9 June 2021

Parramatta West Public School Redevelopment-Mod-3 (SSD-8790-Mod-3)
Request for additional information

Figure 2: Location of demountables to be removed and proposed for retention

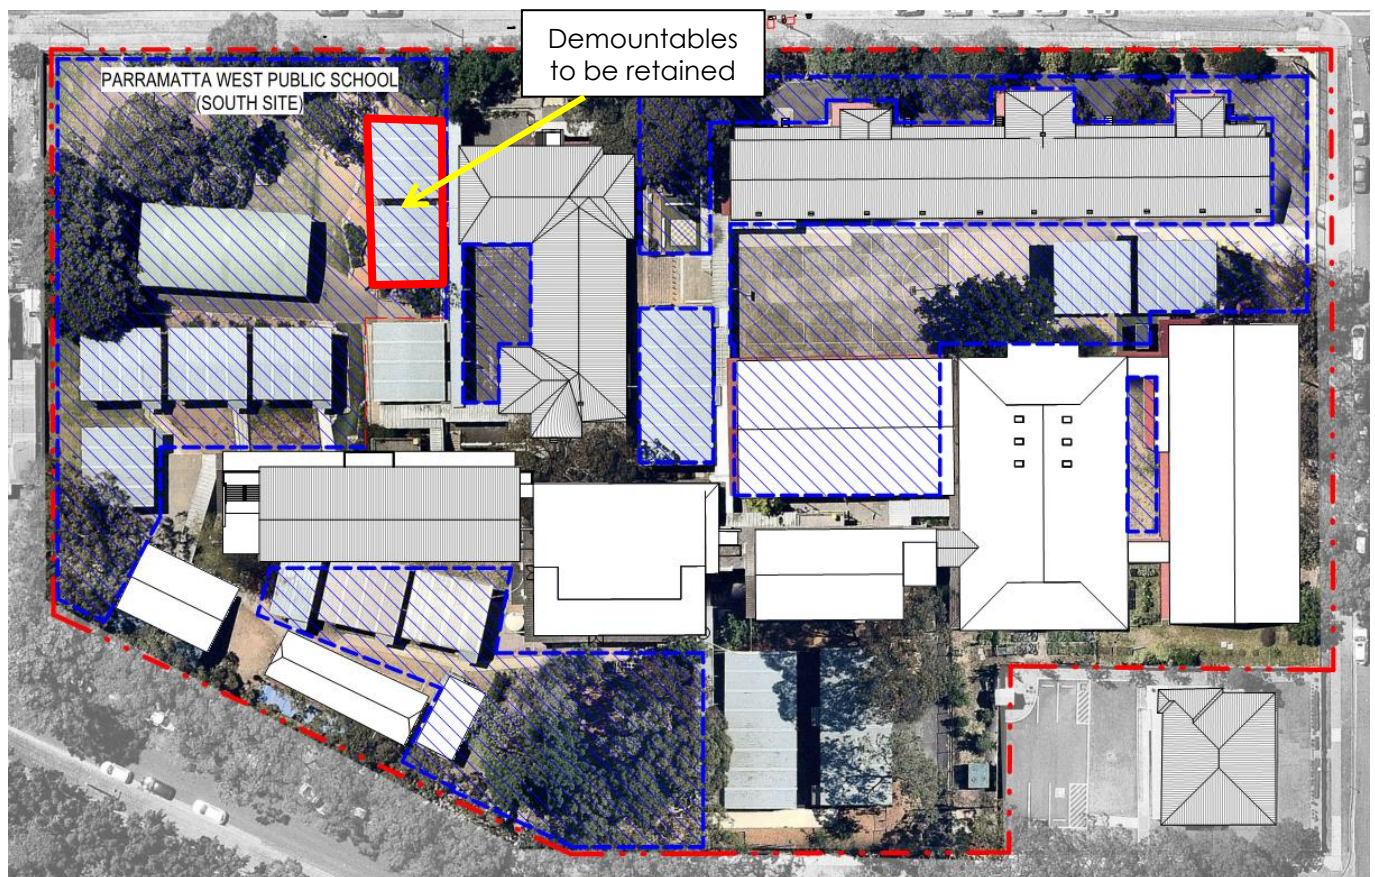
- Heritage issues need to be accurately addressed in a Statement of Heritage Impact. The modification application provides minimal consideration of potential heritage impacts, however a justification used for the original re-development of Parramatta West Public School was the removal of the demountable buildings around the heritage buildings and improved heritage outcomes. As two demountable buildings in close proximity to a heritage building are now proposed to be retained, additional justification is required in the form of a Statement of Heritage Impact as to why this is now acceptable.
- Please add the required information at Appendix A and B within the Modification Report, and include appropriate references within the Modification report.
